DEPARTMENT OF PARKS AND COMMUNITY SERVICES

February 12, 2024

Subject: Mayberry Filing No.2A CS Rezone - (CS234)

VACATIONS OF PREVIOUSLY PLATTED LOTS, ROWs AND EASEMENTS IN MAYBERRY, COLORADO SPRINGS FILING NO. 2

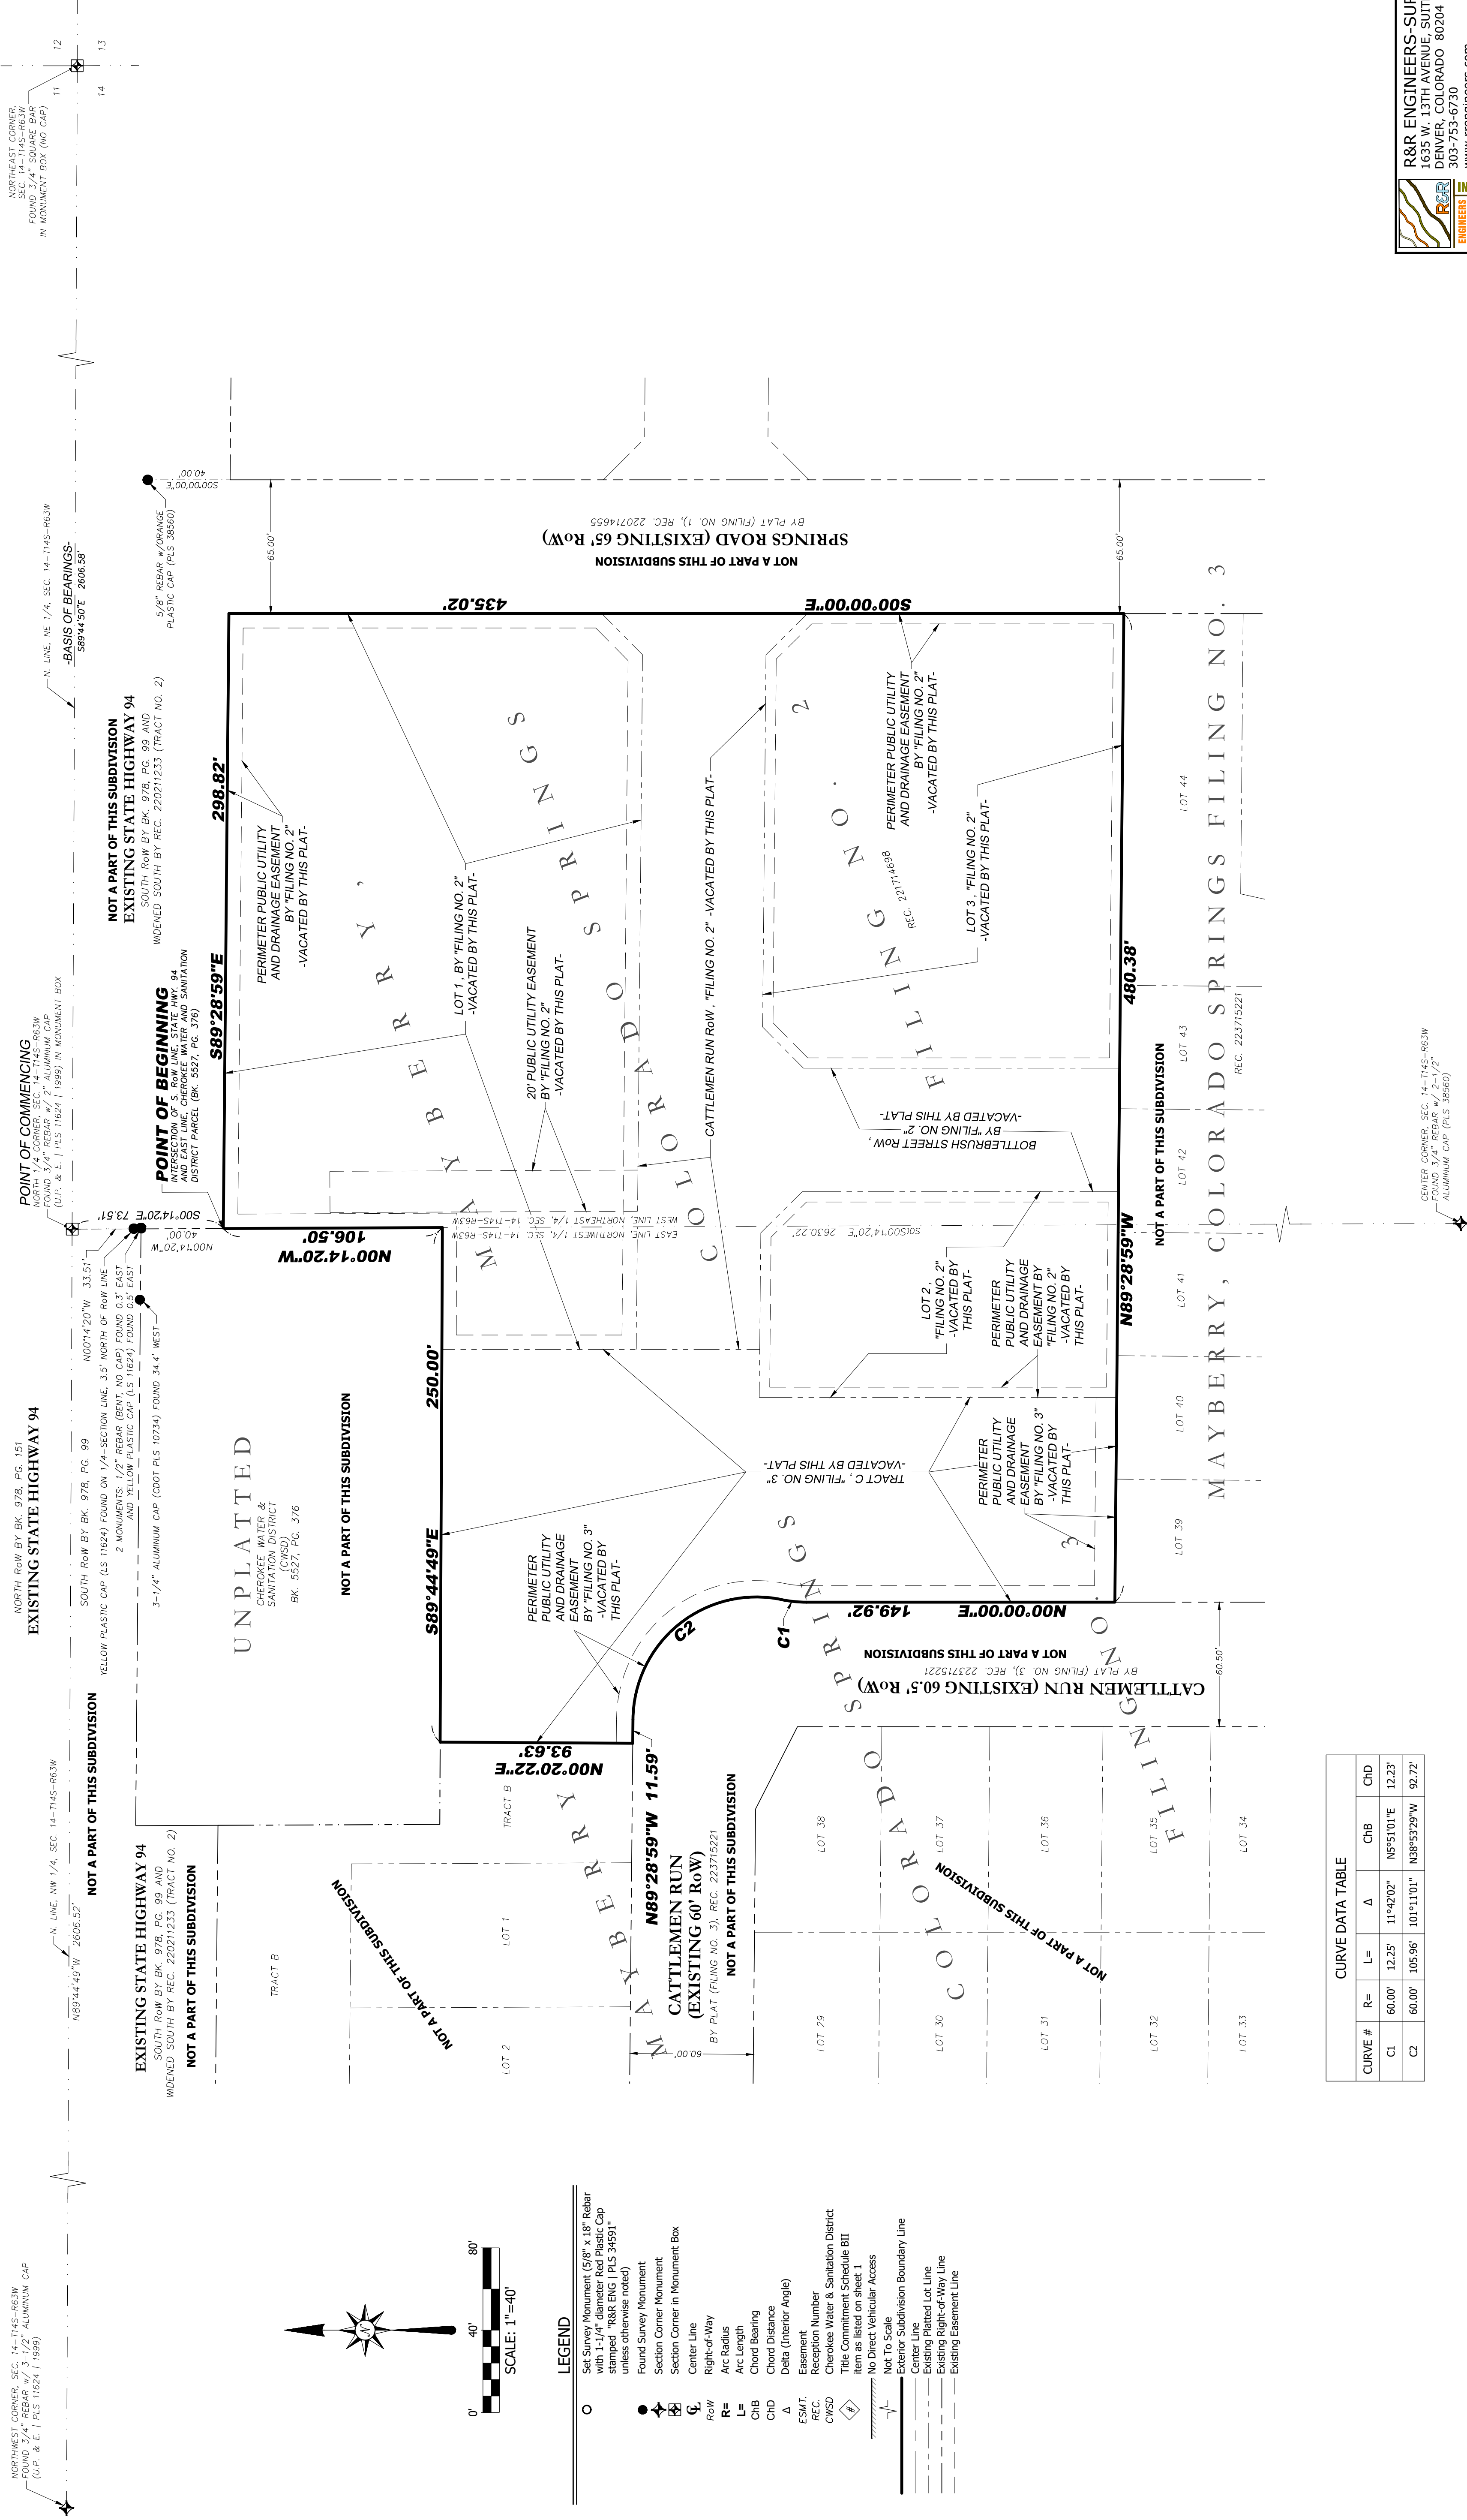
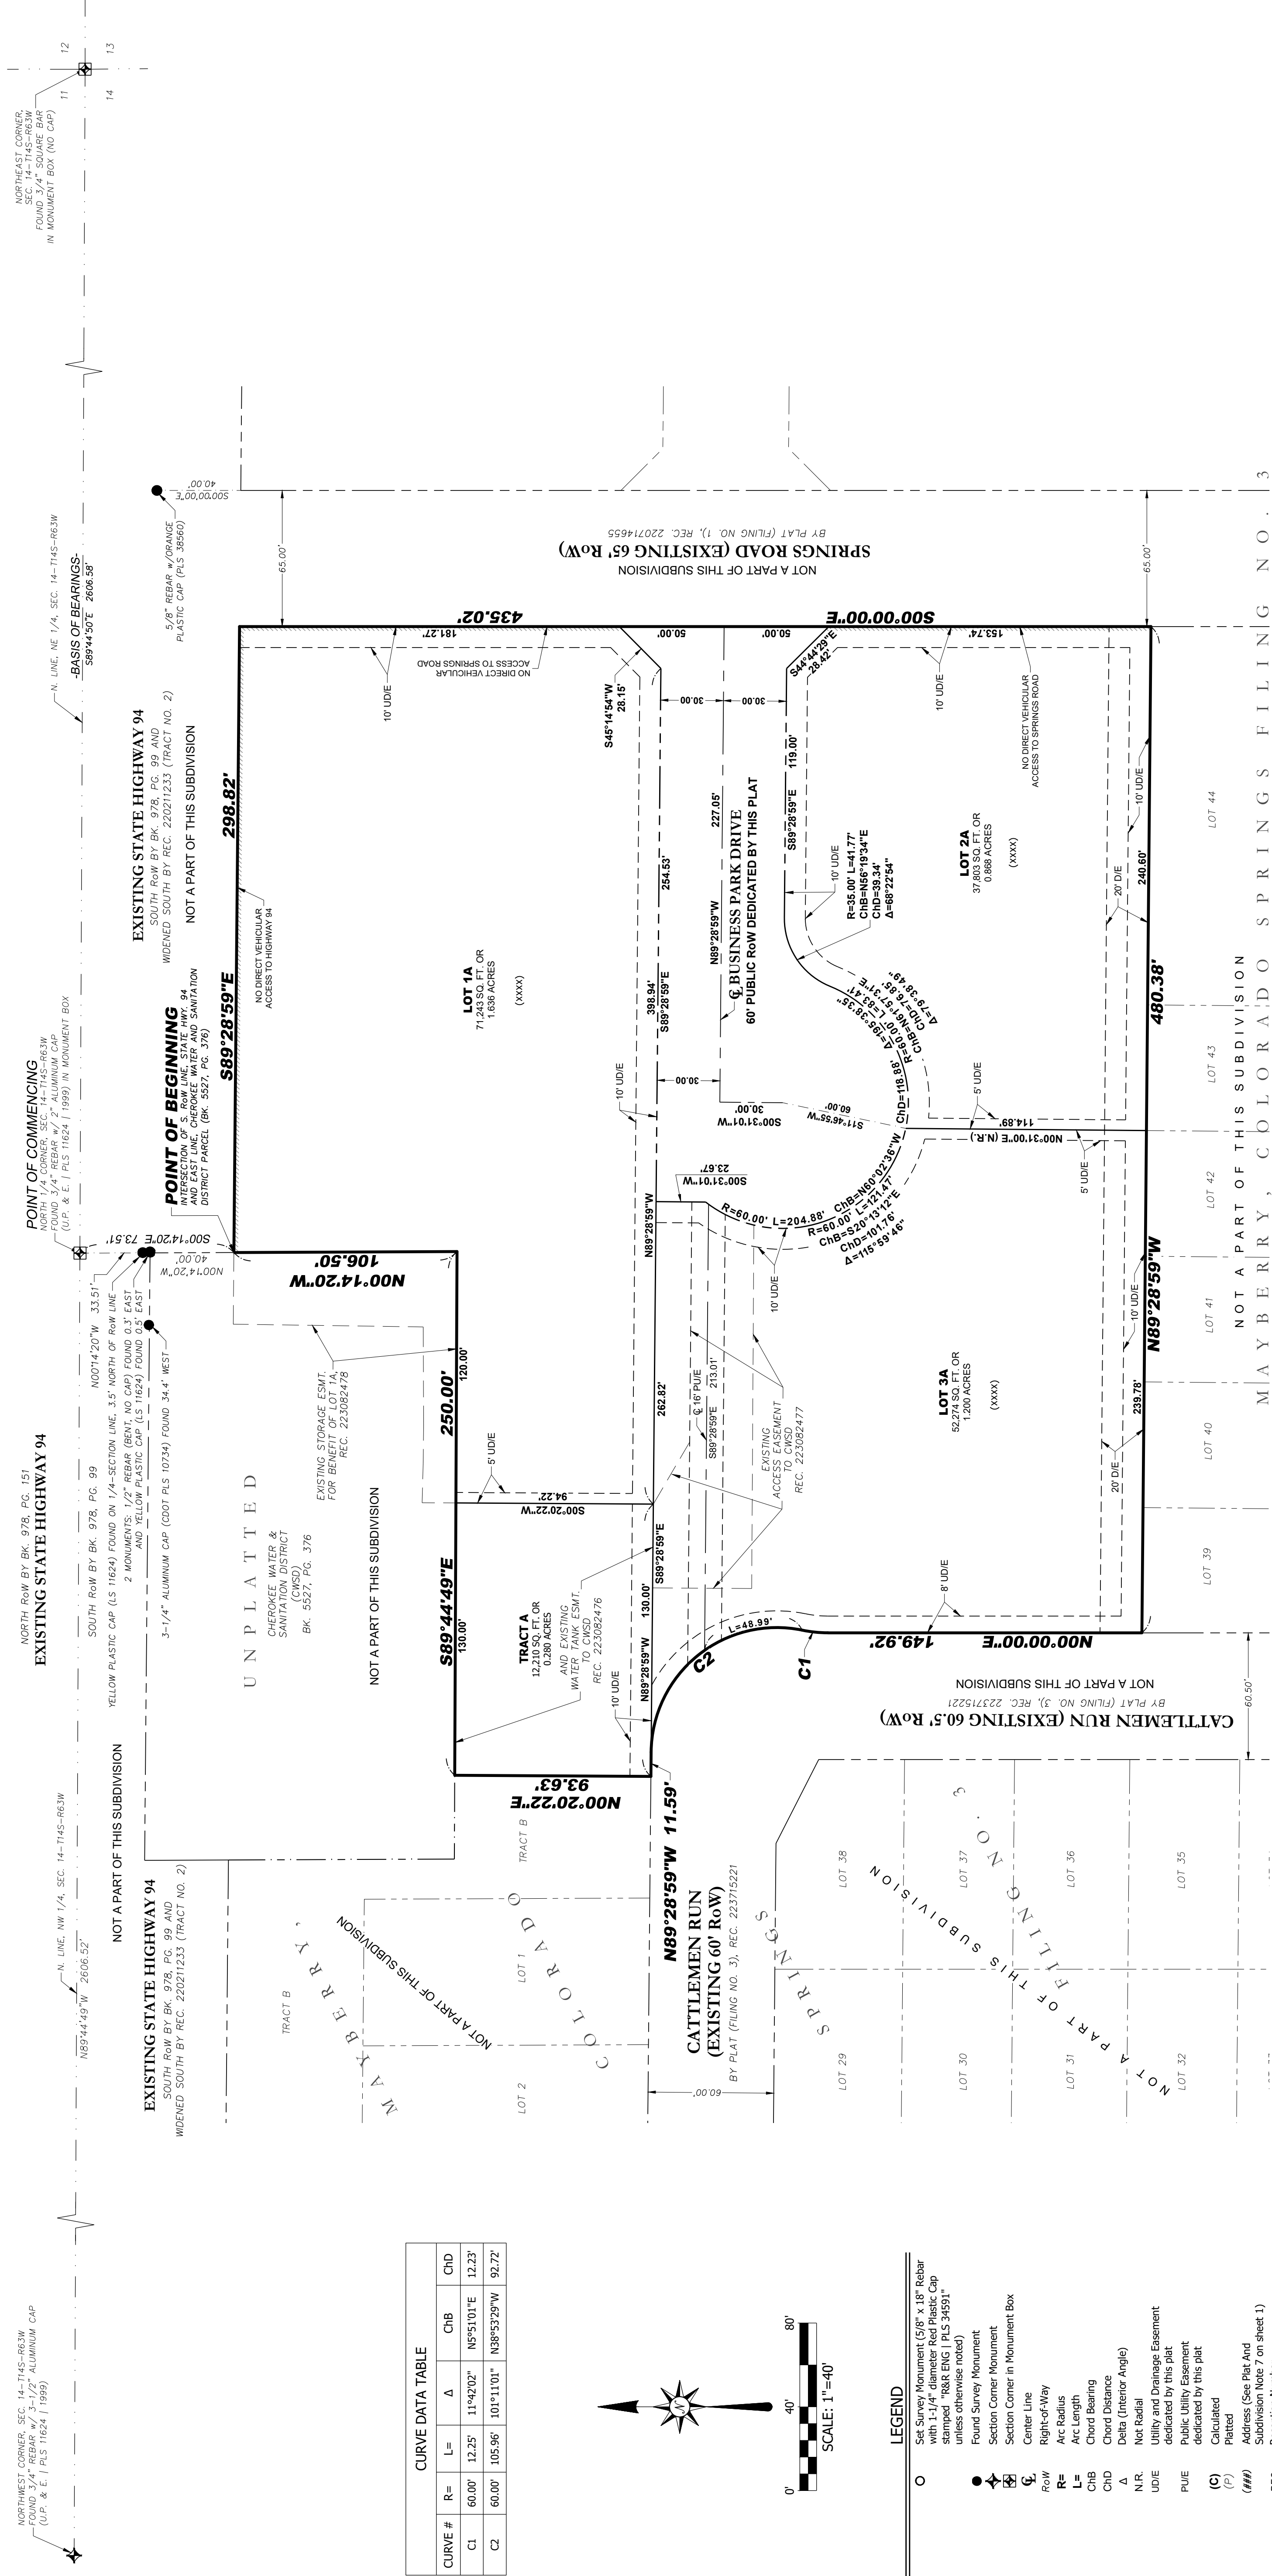
County Parks requests trail easements where development projects impact proposed County trails. As it pertains to this application, the County requests that the landowner provide a 25-foot public trail easement along the south side of Highway 94 and around the south side of the Cherokee Water & Sanitation parcel to make a connection to allow for the construction and maintenance by El Paso County of the Highway 94 Primary Regional Trail, and this easement shall be shown and dedicated to El Paso County on the Final Plat.

Recommend that the Planning Commission and the Board of County Commissioners include the following conditions when considering and/or approving the Mayberry Filing No.2A CS Rezonet: (1) Provide a 25-foot public trail easement along the south side of Highway 94 outside of the public right-of-way and south of the Cherokee Water & Sanitation parcel that allows for the construction and maintenance by El Paso County of a Primary Regional Trail, and this easement shall be shown and dedicated to El Paso County on the Final Plat. (2) Provide an alternative trail alignment for the Highway 94 Primary Regional Trail through the Mayberry development for El Paso County Parks review.
